An  
Bord  
Pleanála

## Inspector's Report

### ABP-317874-23

Extraction of sand and gravel from quarry. An Environmental Impact Assessment Report (EIAR) and a Natura Impact Statement (NIS) have been submitted.

DRAWING TITLE:
Updated Phased Restoration Plan
DRAWING STATUS:
Planning

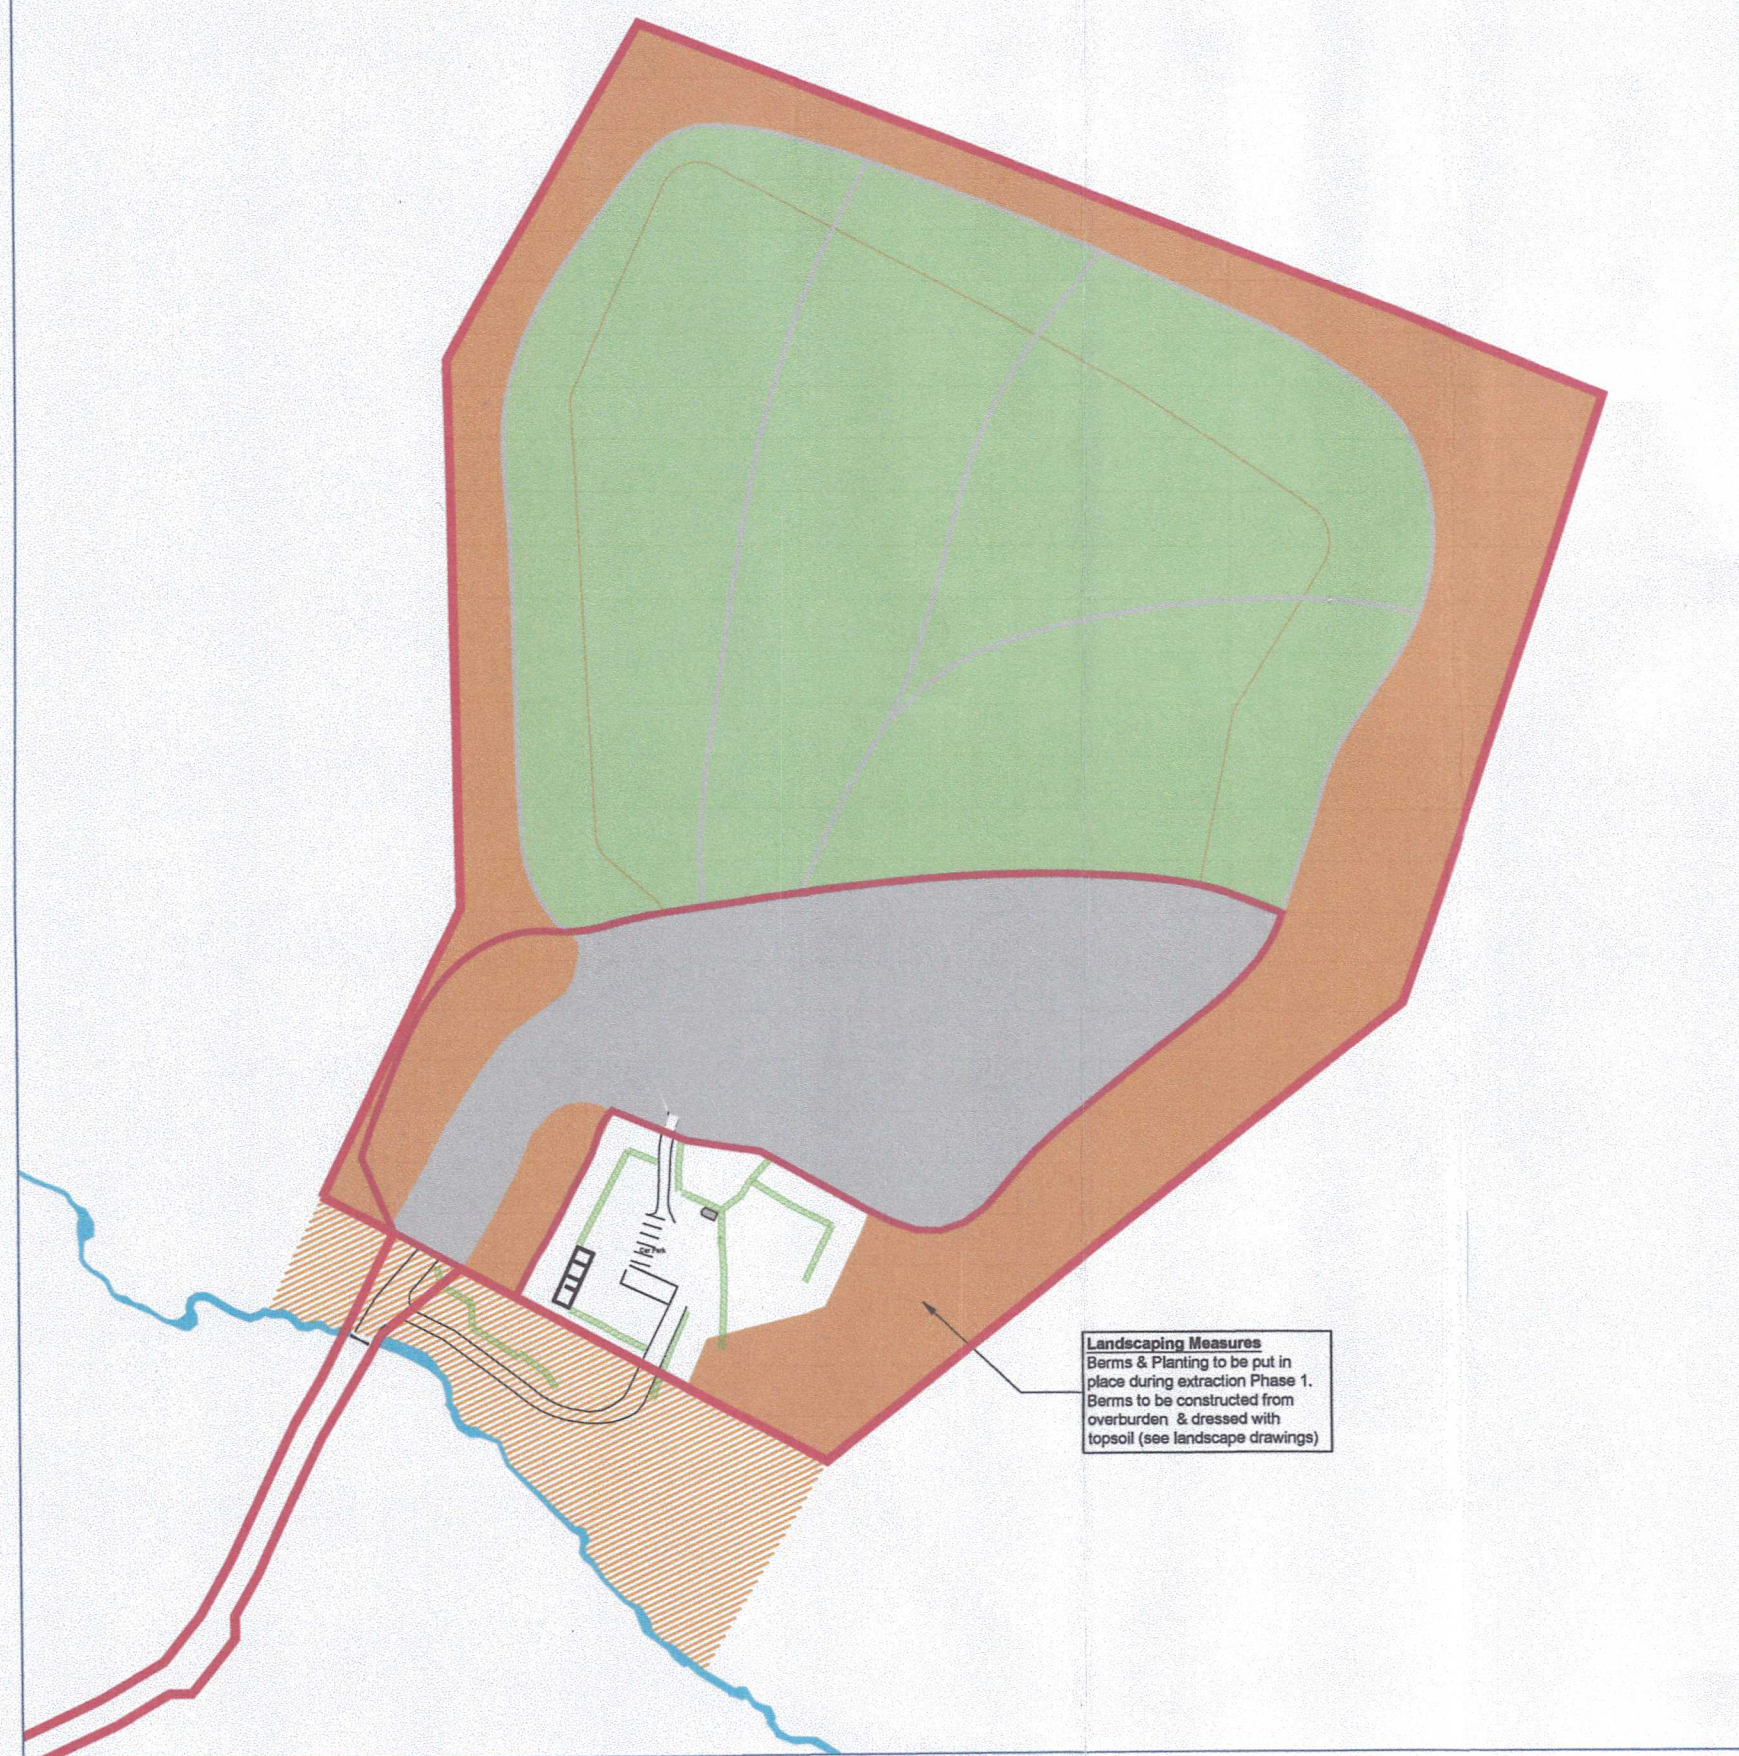
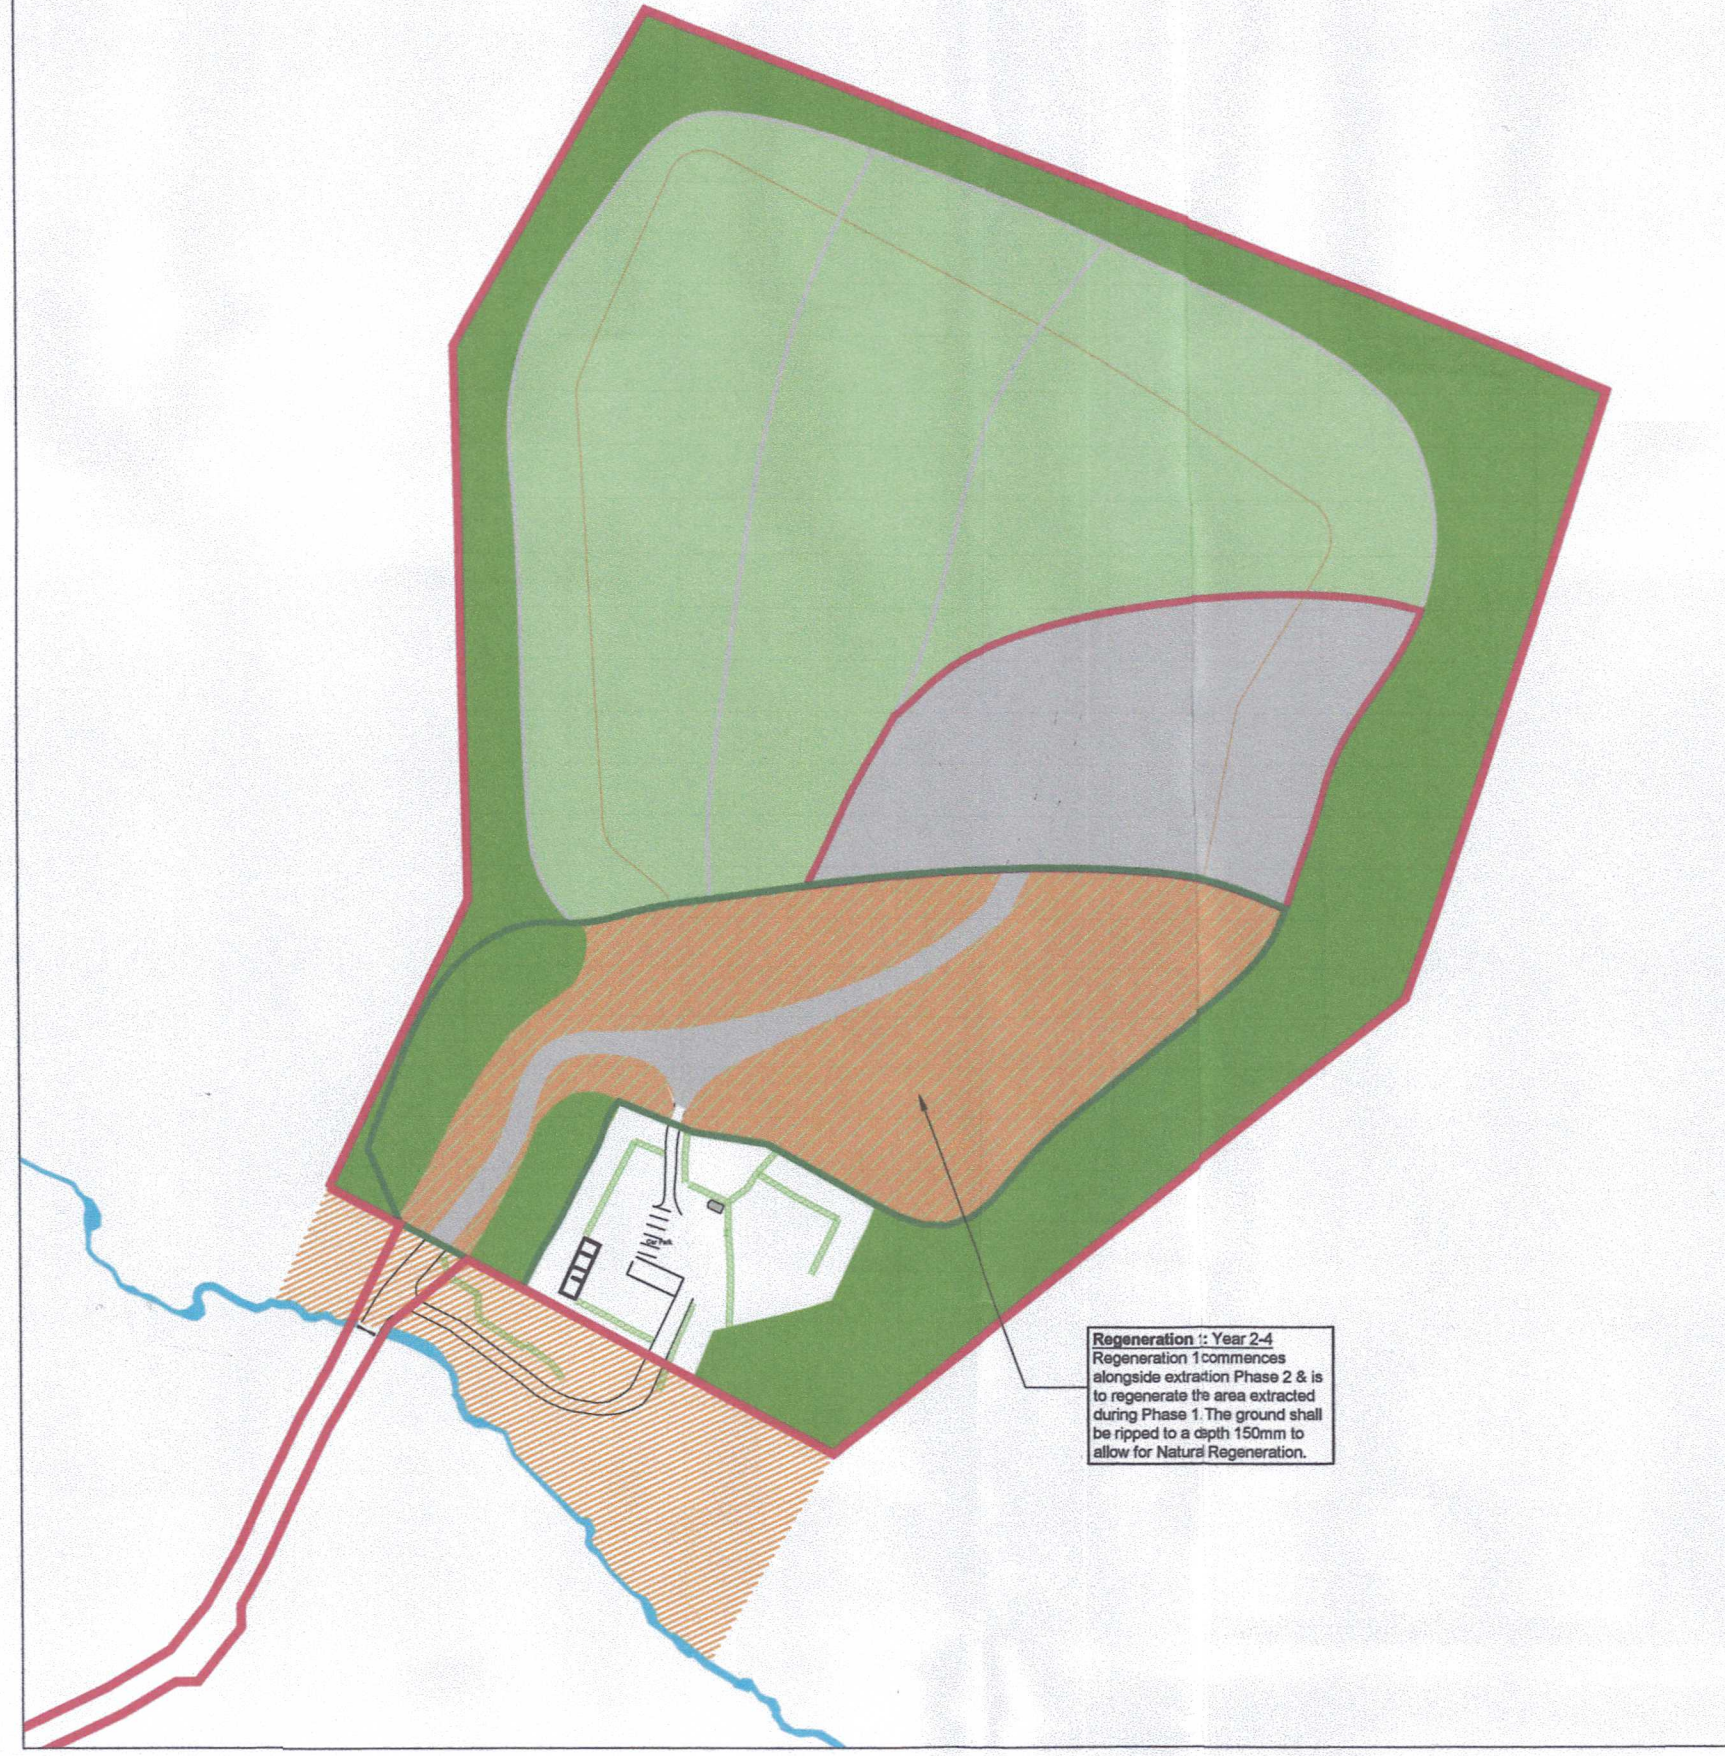
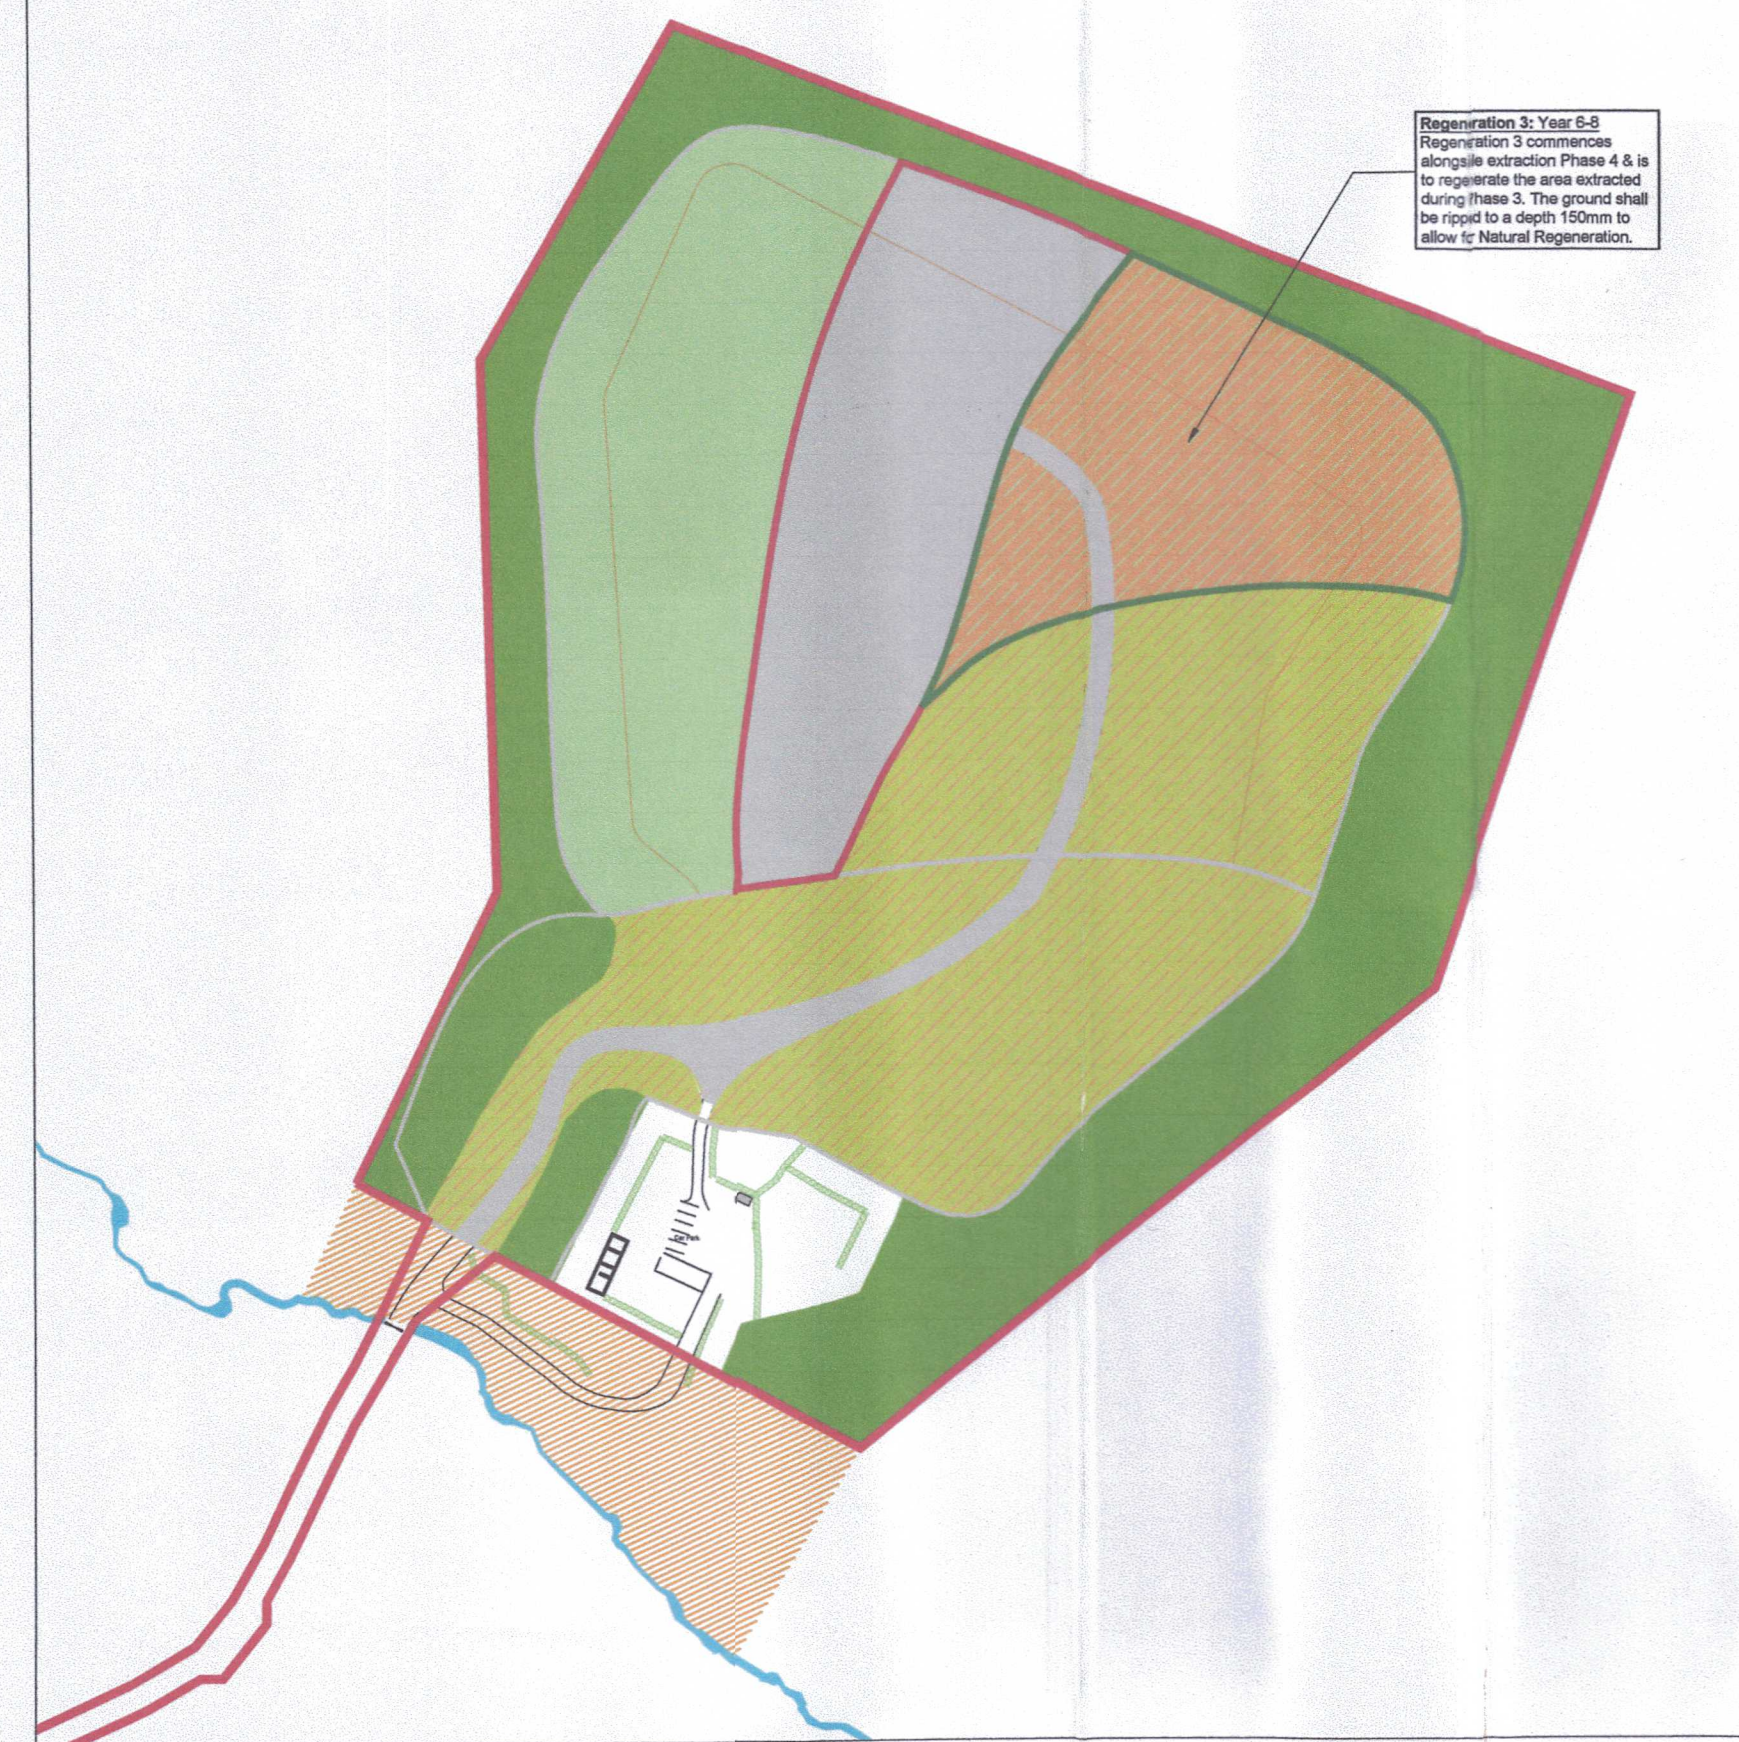
- The Environmental Impact Assessment Report and Natura Impact Statement are deficient in their failure to provide sufficient information/ assessment of the Restoration of the extracted area, which is considered integral to the sand/ gravel extraction. In the absence of such information the proposed development may give rise to significant and adverse effects on the amenities of the area, give rise to a serious traffic hazard, and impact negatively on the environment. The proposed development would, therefore, be contrary to the requirements of the Habitats Directive, to Directive 2014/52/ EU (EIA Directive), to the objectives of the County Development Plan 2022-2028, which seeks to ensure that aggregate exploitation does not unduly impinge on the environmental quality, and the visual and residential amenity of an area. The development would therefore be contrary to proper planning and sustainable development of the area.

3.2.1.4. Within their response document (Part 1), the Applicant noted that there had been a change in the project description, and it was now proposed that restoration activities will be phased and happen concurrently with the phasing of extraction activities. A sequencing of the restoration phase compared to the extraction phasing is set out in Table 2-1 of their response document and they referred to the Updated Restoration Plan that accompanied their response. In addition to the supplementary assessments
